Our reference : DOC10/42610 @ FIL10/5971
Contact : Nicolas Israel (02) 9995 6821

Daniel Cavallo
Acting Director, Government Land and Social Projects
Department of Planning
GPO Box 39
SYDNEY NSW 2001

**Re: Exhibition of Modification Environmental Assessment for Royal North Shore Hospital
St Leonards – MP08_0172 MOD3**

Figure 9: South elevation view near landing pad with east end of intakes outlined in blue

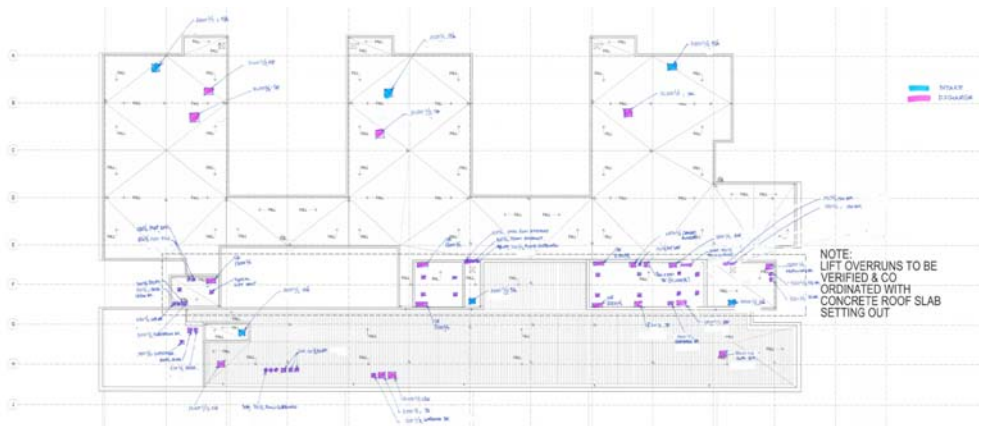
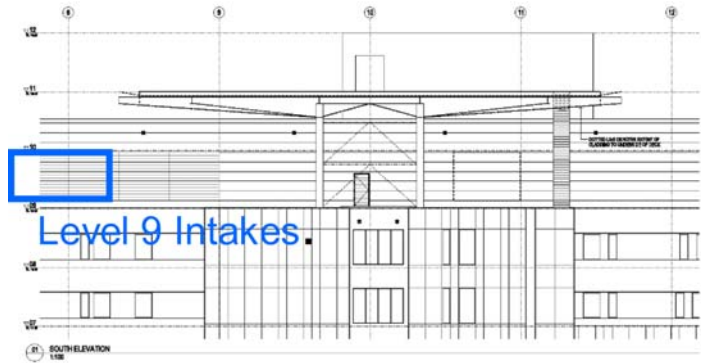
Based on the information included in the above EA report, it appears that exhaust air emissions generated by the helicopter are highly likely to enter the building through the air intakes located at various levels of the building. DECCW recommends that the proponent gives appropriate consideration to this issue to ensure that these emissions do not have adverse impact on the occupants (patients, staff and visitors) of the building.
